File No: EF14/5457
Ref No: DOC19/614141

**The Sandstone Precinct 23-33 and 35-39 Bridge Street, Sydney, Stage 2 Modification
4 – Design changes to Lands Department Building.**

(SSD 7484 MOD 4)

3 PROPOSED NORTH COURTYARD ELEVATION - SOUTH
1:200

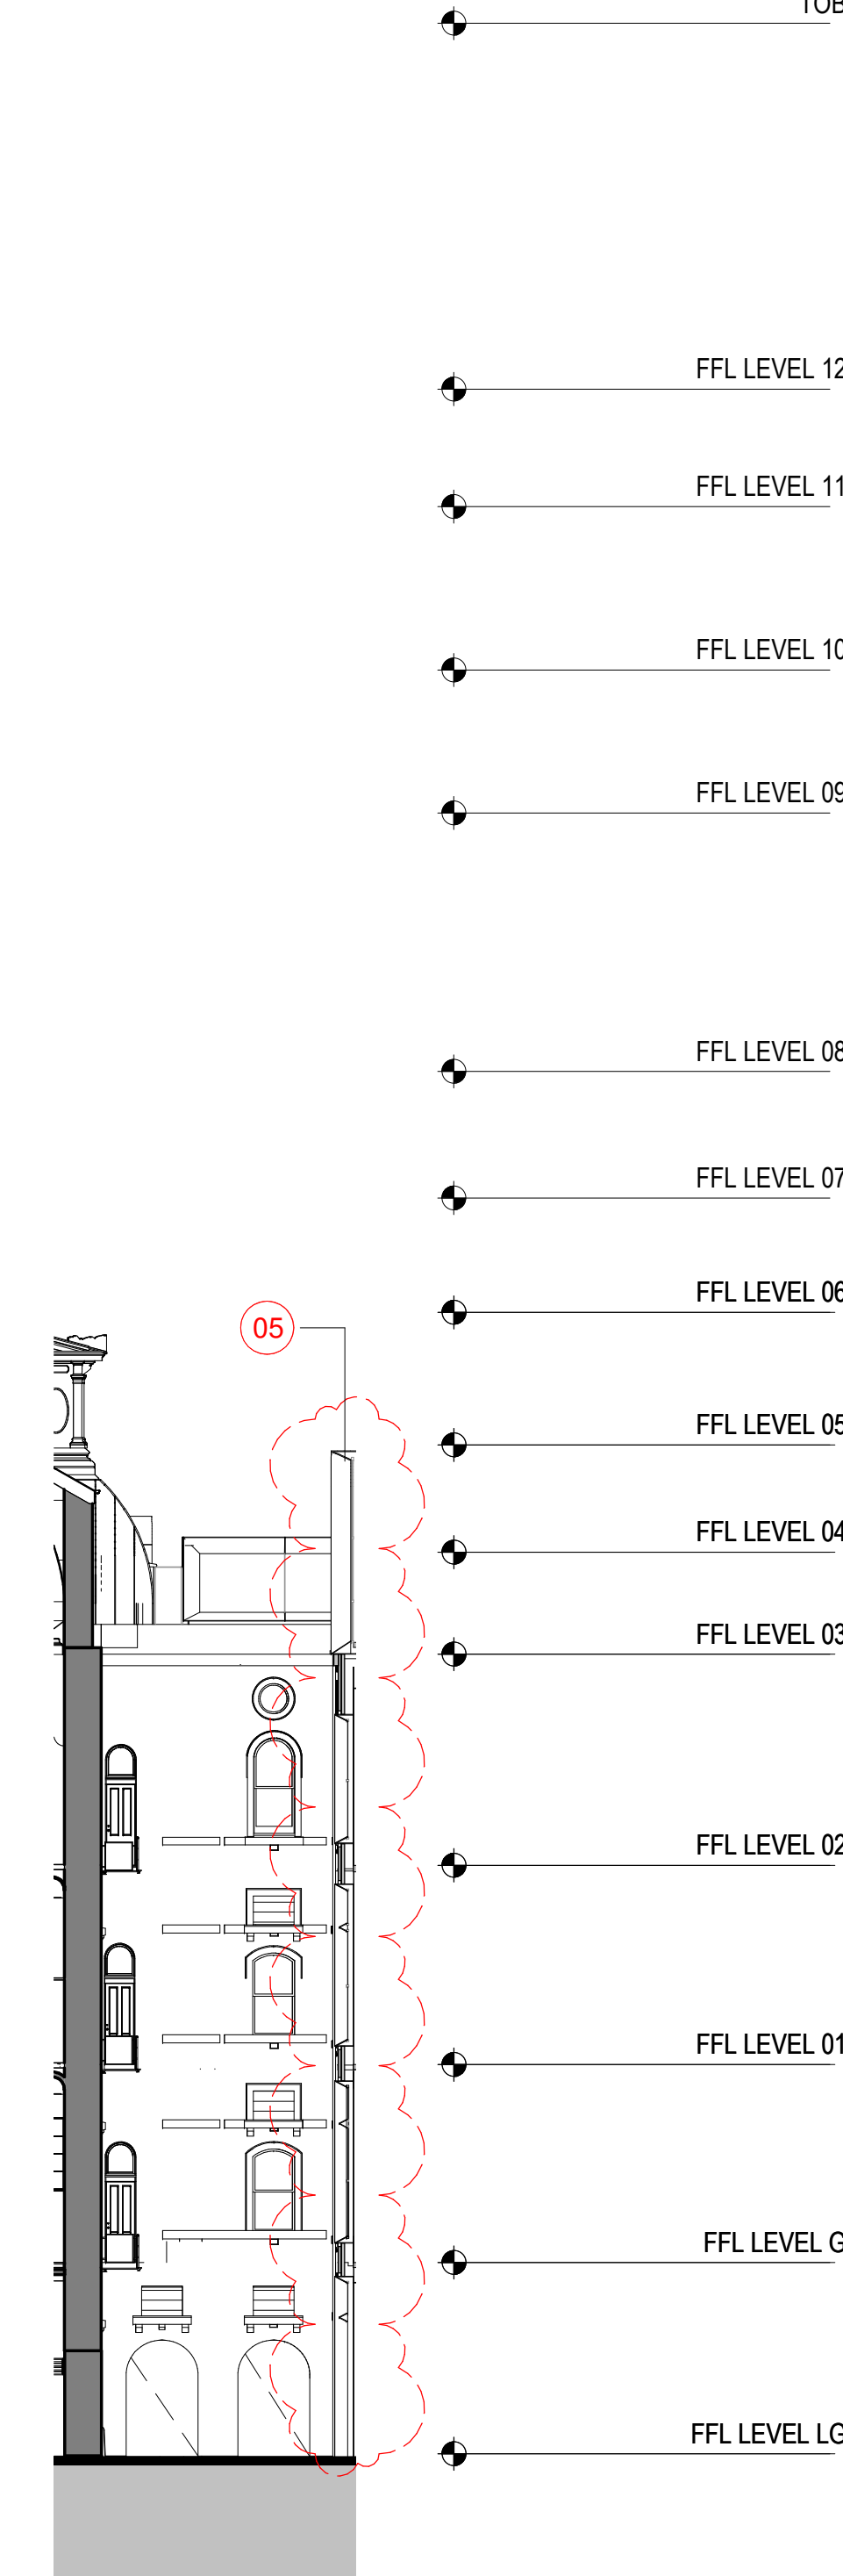
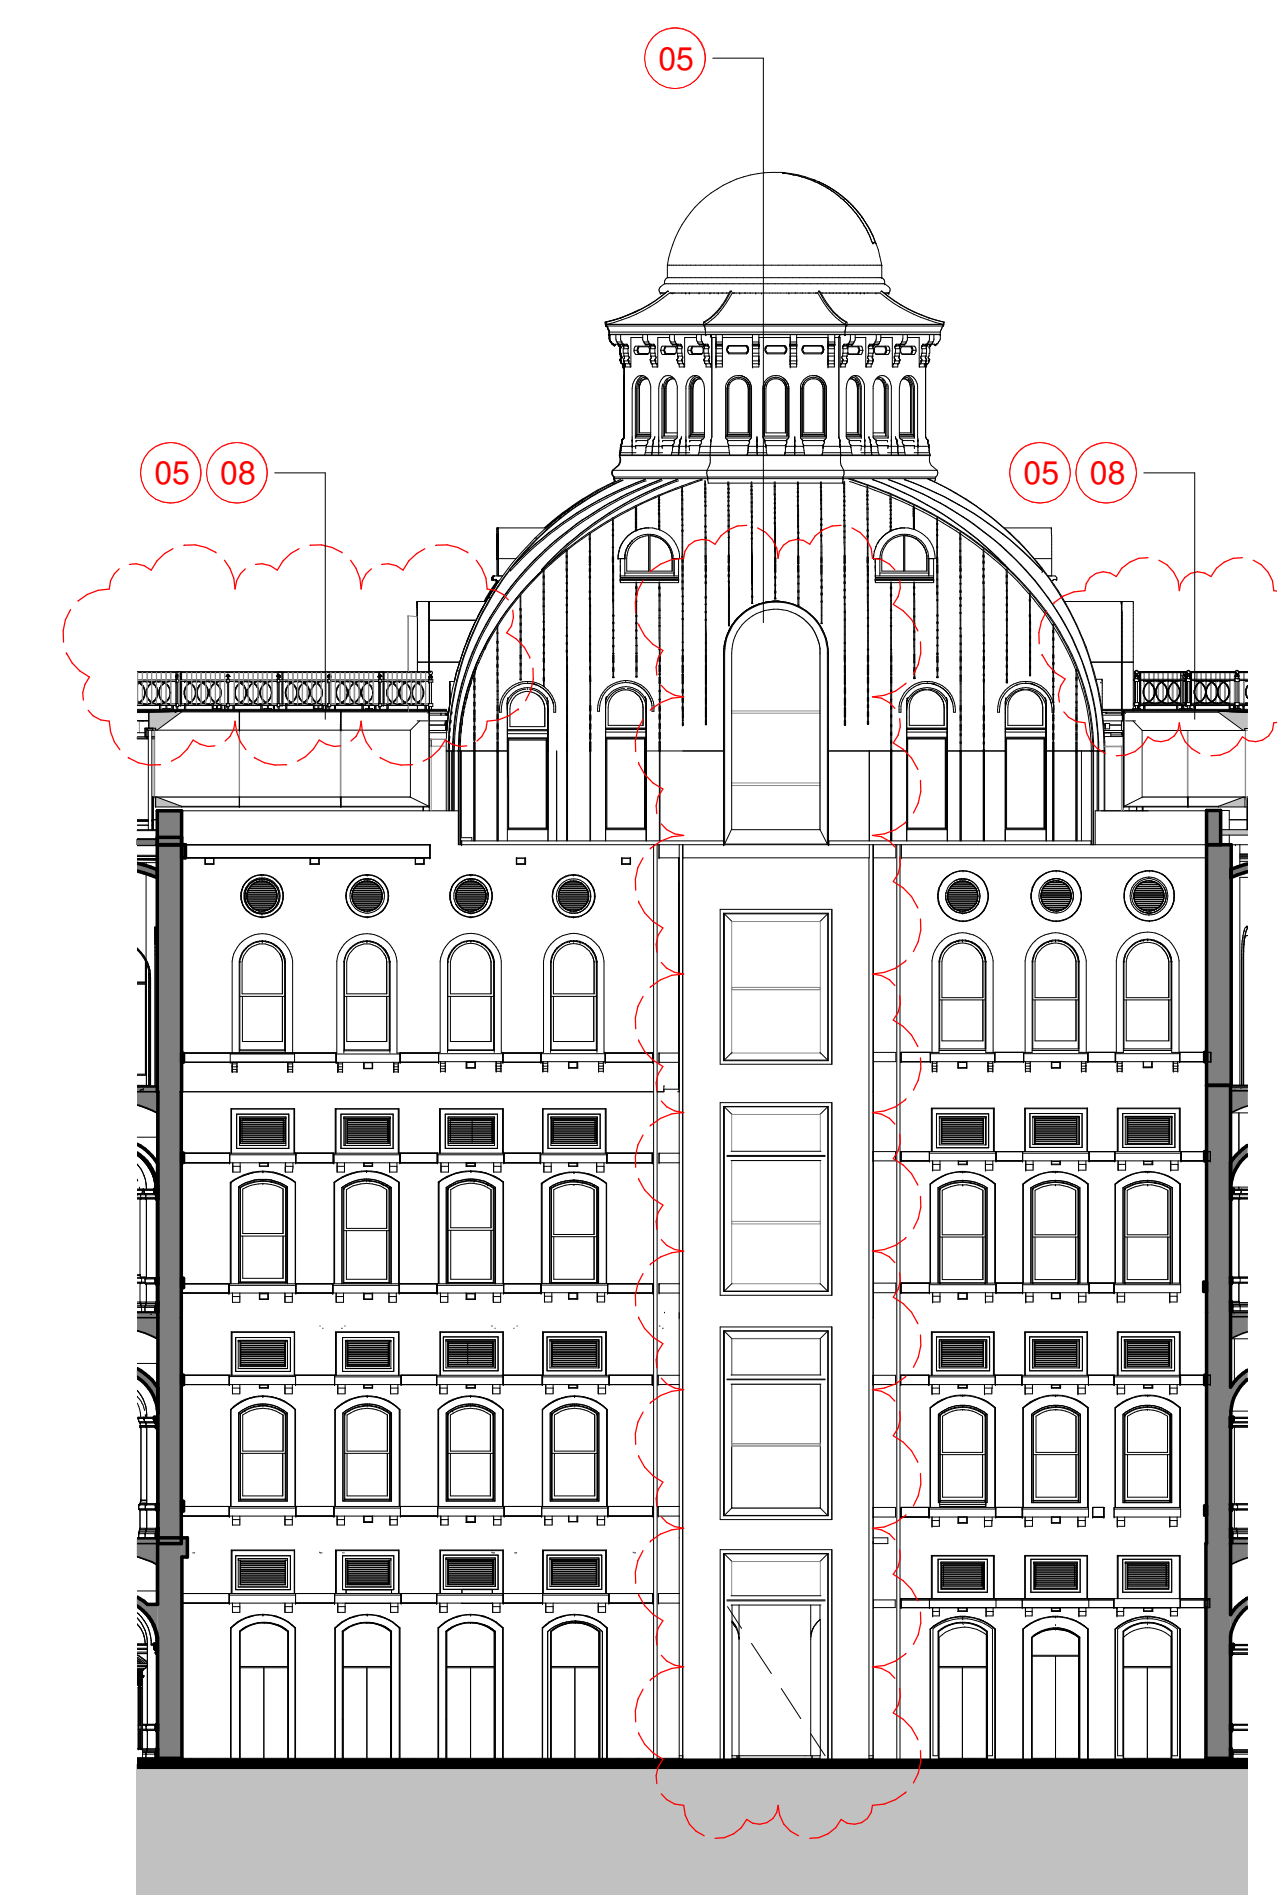
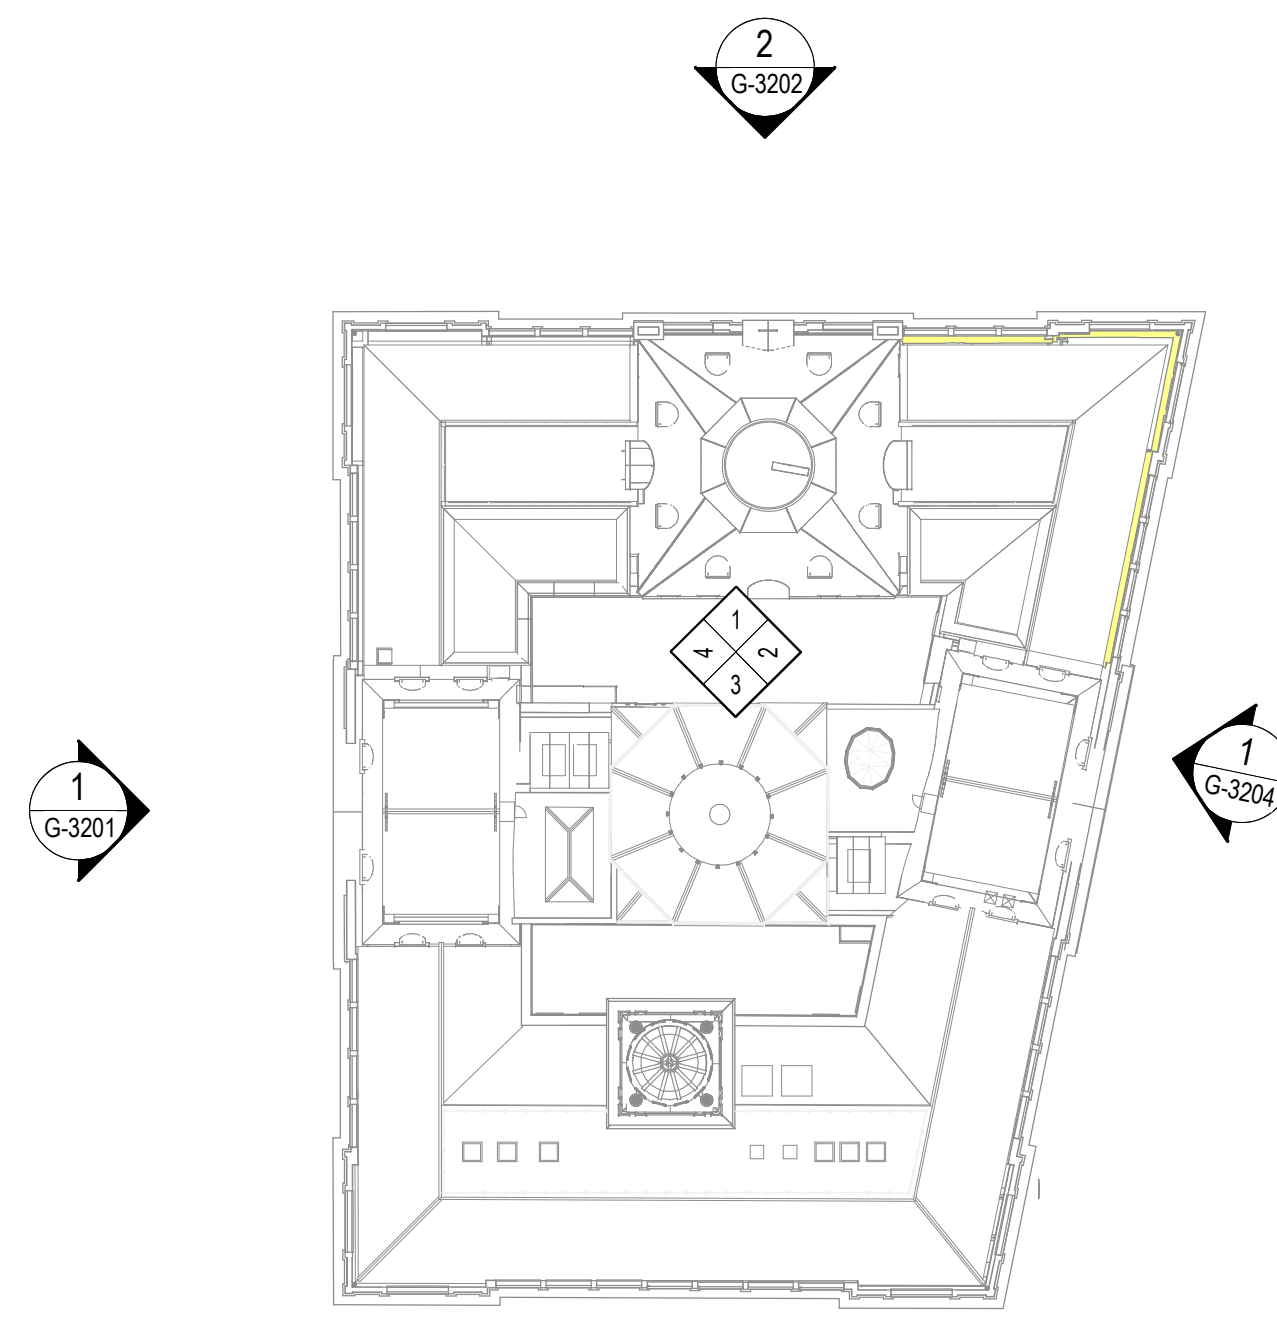
- **Courtyards:** The removal of intrusive structures and altered walkways is in accordance with the policies in the endorsed CMP and will have an acceptable heritage impact. The new multistorey slot facing south in the northern courtyard introduces a new architectural element to replace compromised and dysfunctional late twentieth century fabric. This proposed element is clearly identifiable as contemporary fabric, is an excellent design and fabric and is in accordance with CMP Policy 6.2.7 *Any new work should be of design excellence and employ superior materials.*
